3 July 2019

**Re: SECTION 4.55 (1A) MODIFICATION APPLICATION TO SSD 7751
BULLI HOSPITAL AGED CARE CENTRE OF EXCELLENCE
22 HOSPITAL ROAD BULLI**

This Modification Application has been prepared by TCG Planning on behalf of Health Infrastructure NSW, seeking consent to modify various aspects of the SSD 7751 approval at 22 Hospital Road, Bulli (the subject site) pursuant to Section 4.55(1A) of the *Environmental Planning and Assessment Act, 1979* (EP&A Act).

Project No	15617
Scale	As indicated@A1
Date	17/08/2018
Drawn By	Author
Checked By	Checker
Drawing No	Revision
AA-21-0005	014

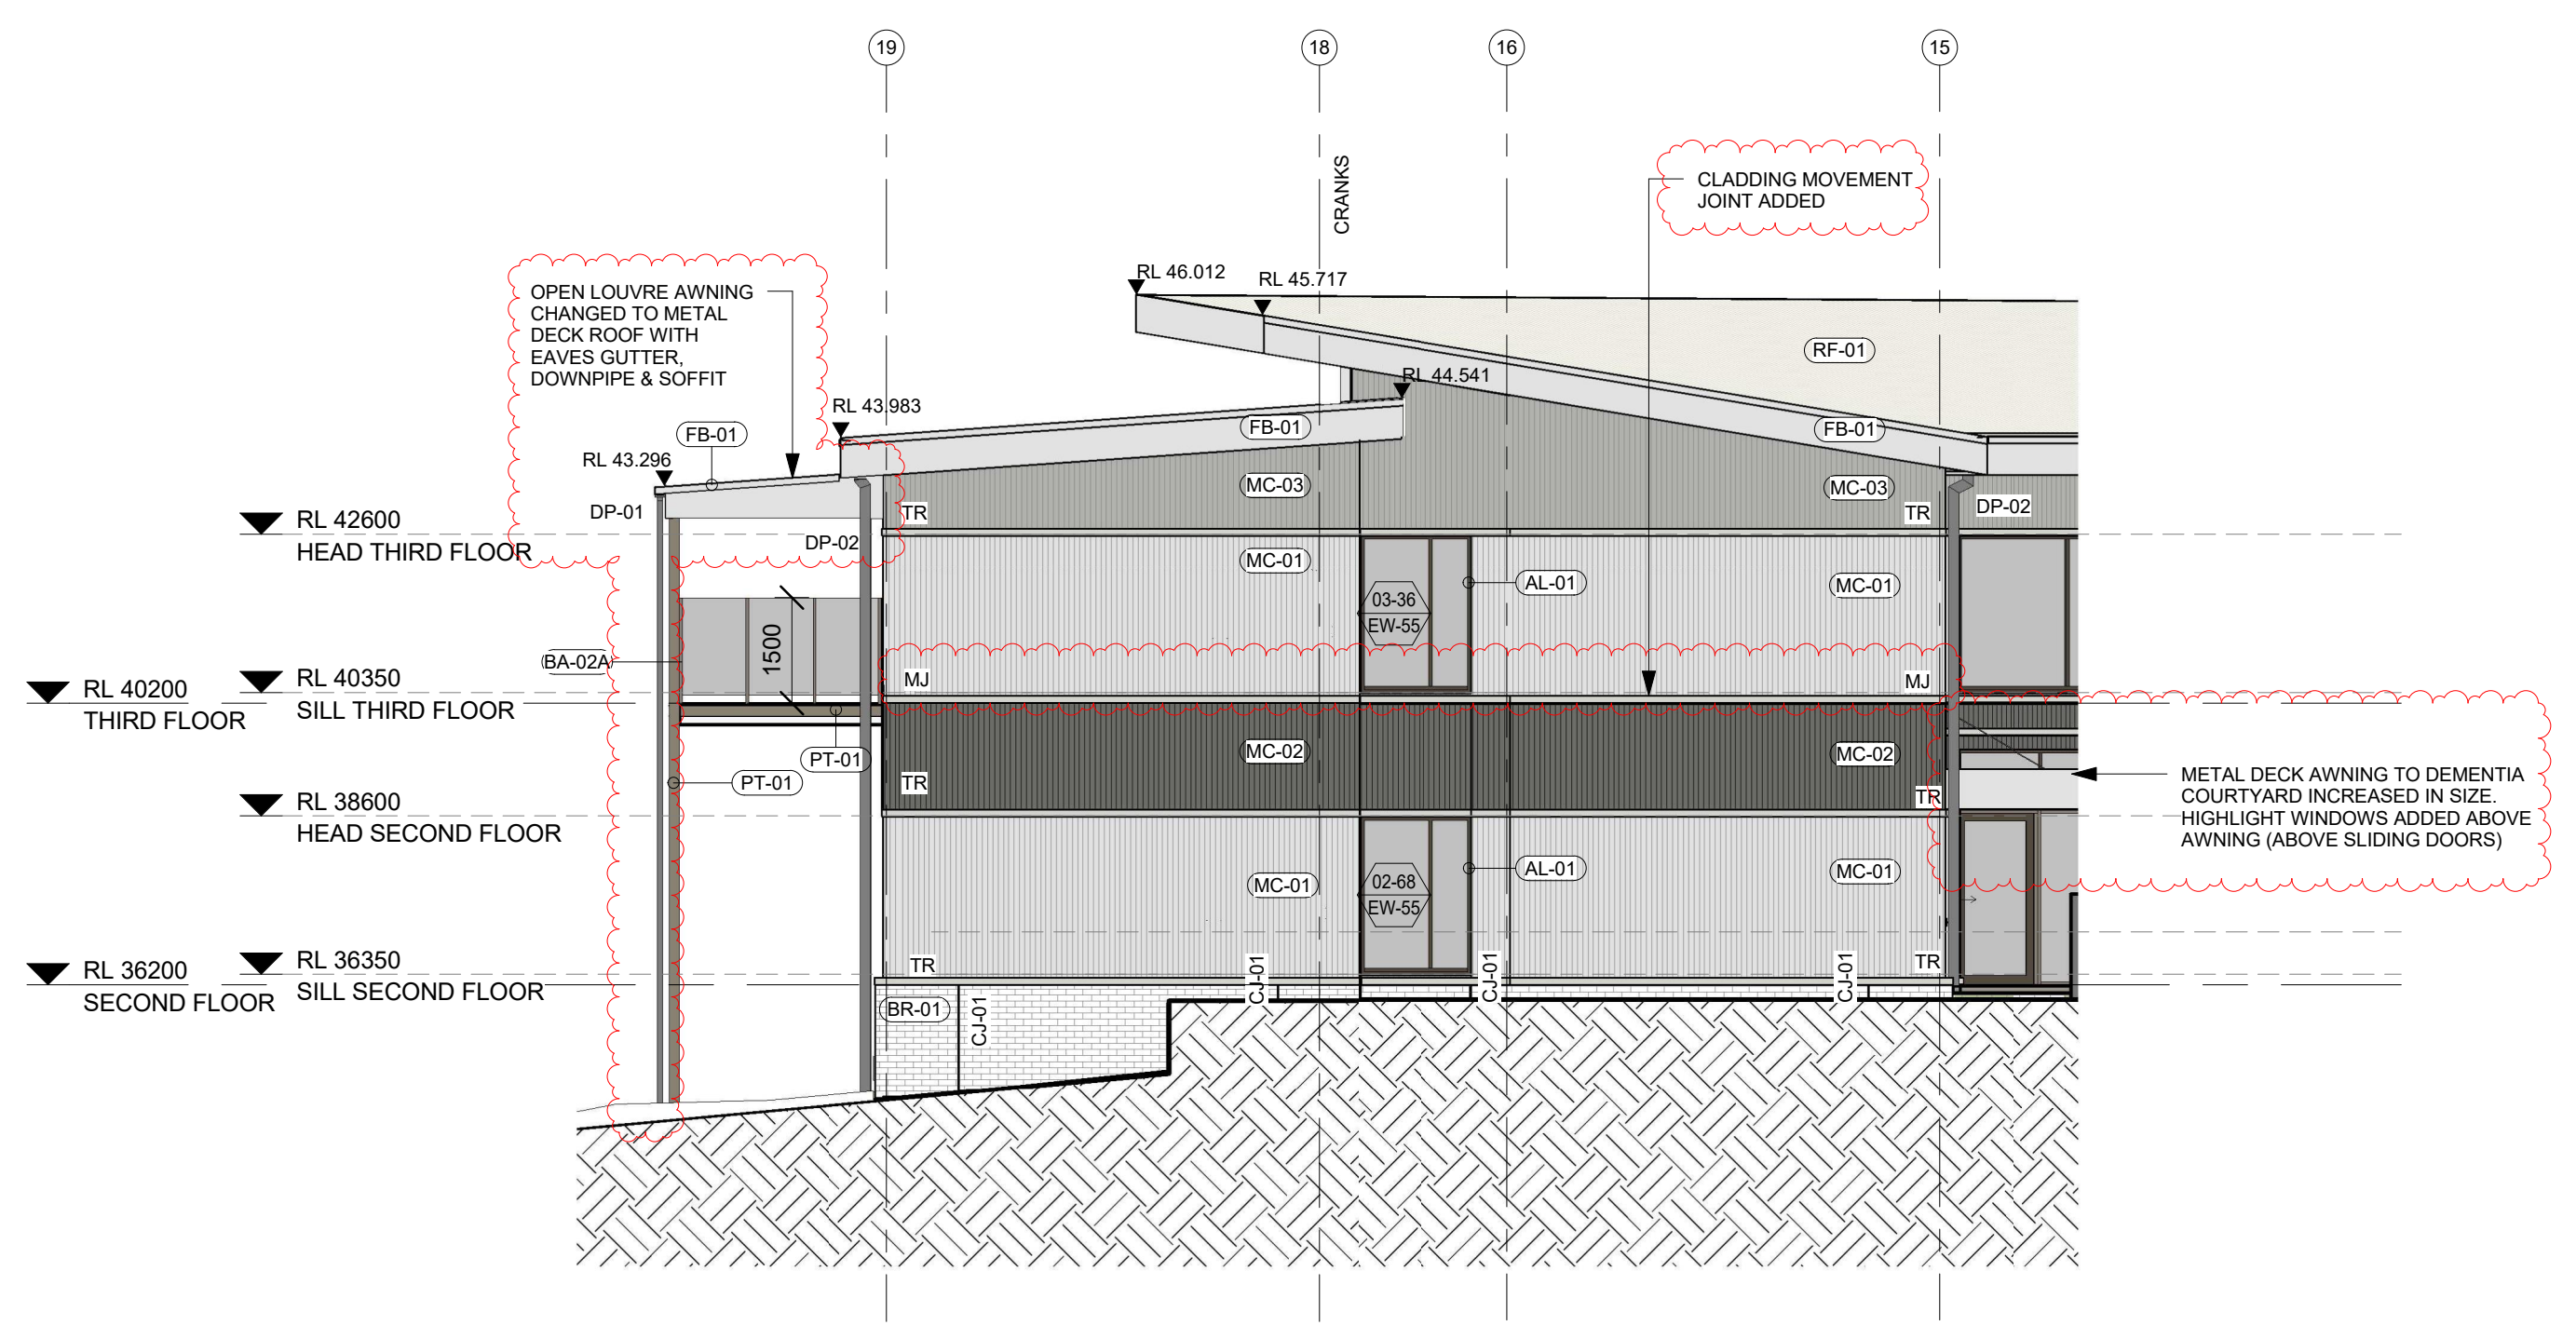
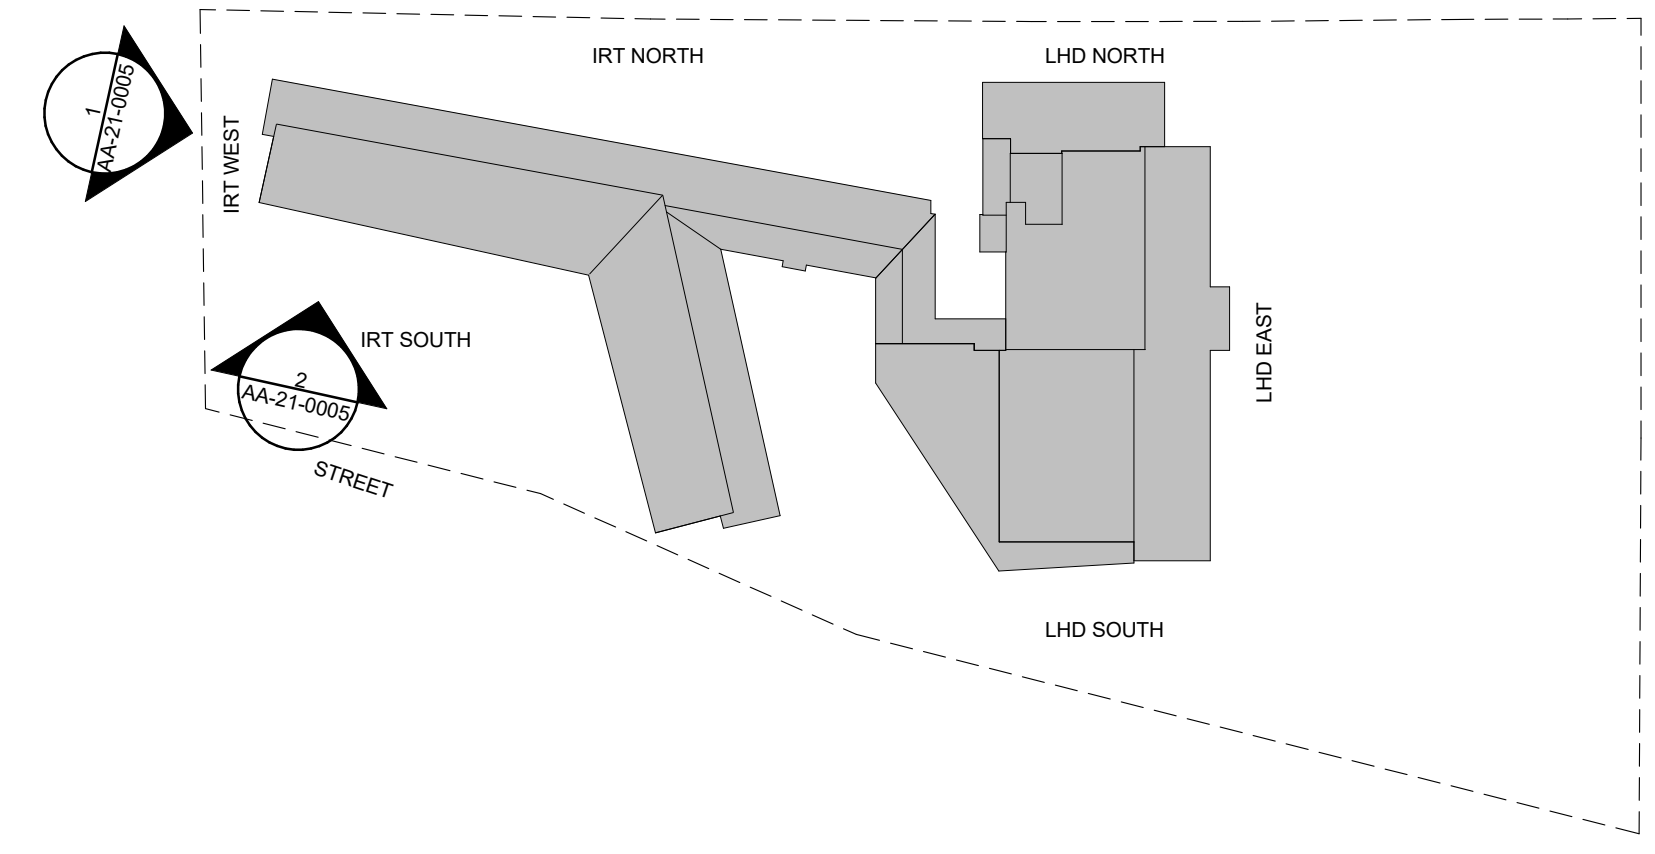
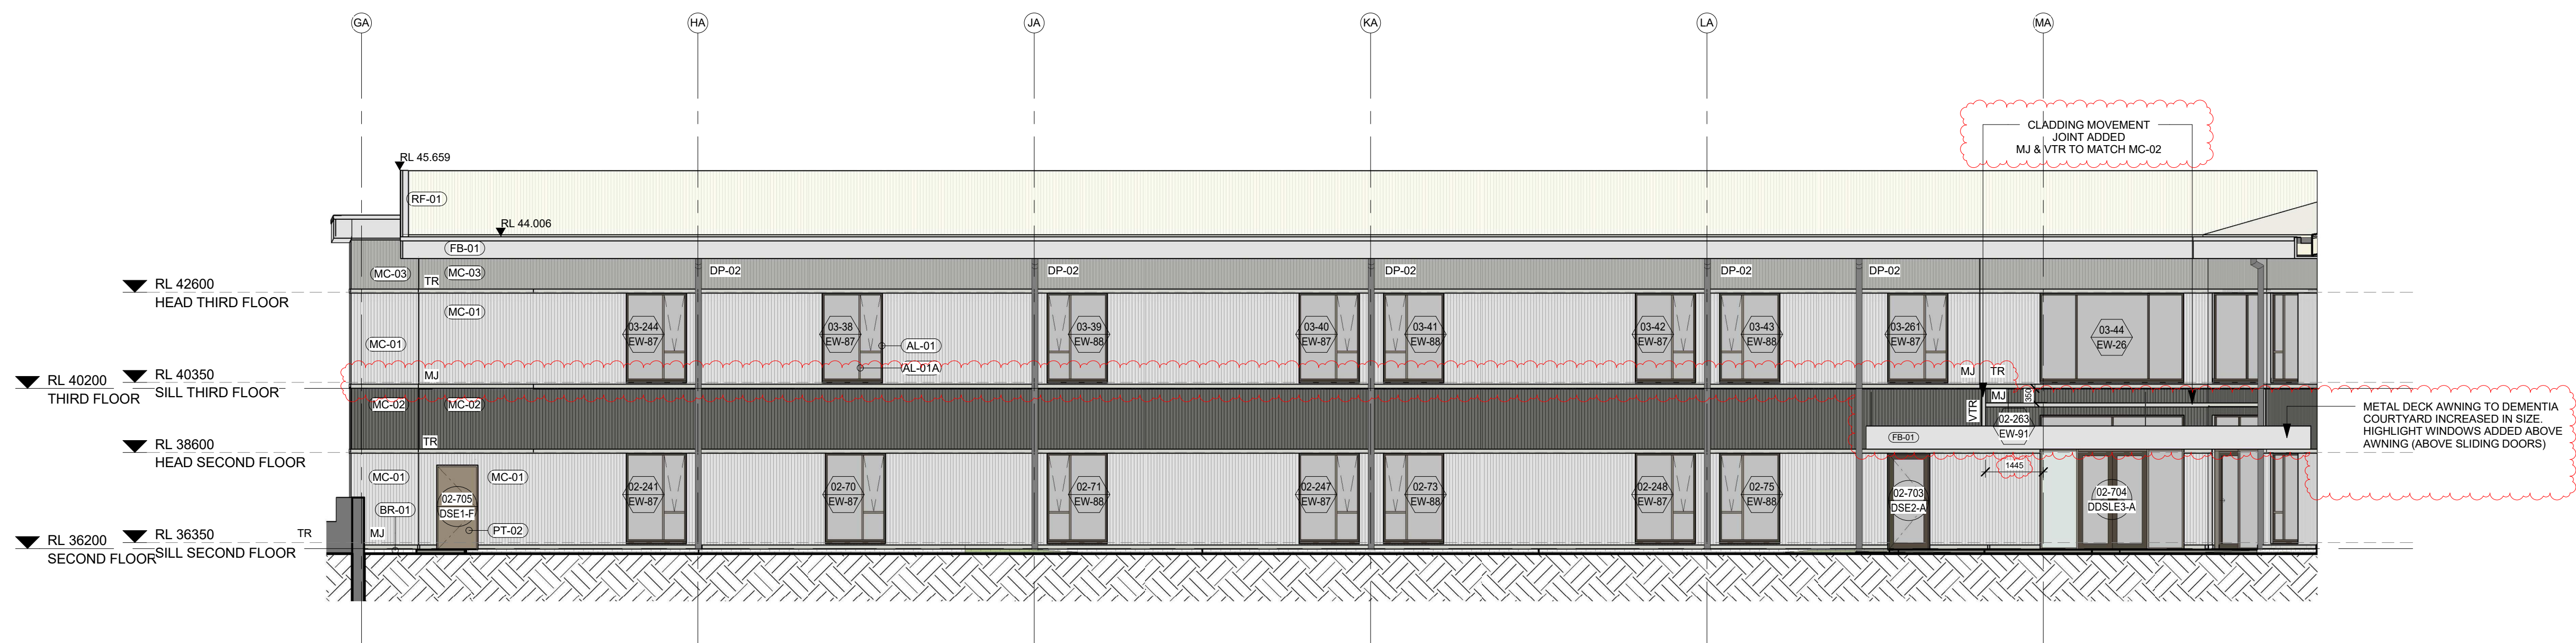
Minor external changes to IRT facility	Billard Leece Plan Dwg: AA-21-0004 and 0005 (Elevation)	Permanent movement joint zone, associated repositioning of window and door to suit; open louvre awning changed to metal deck roof
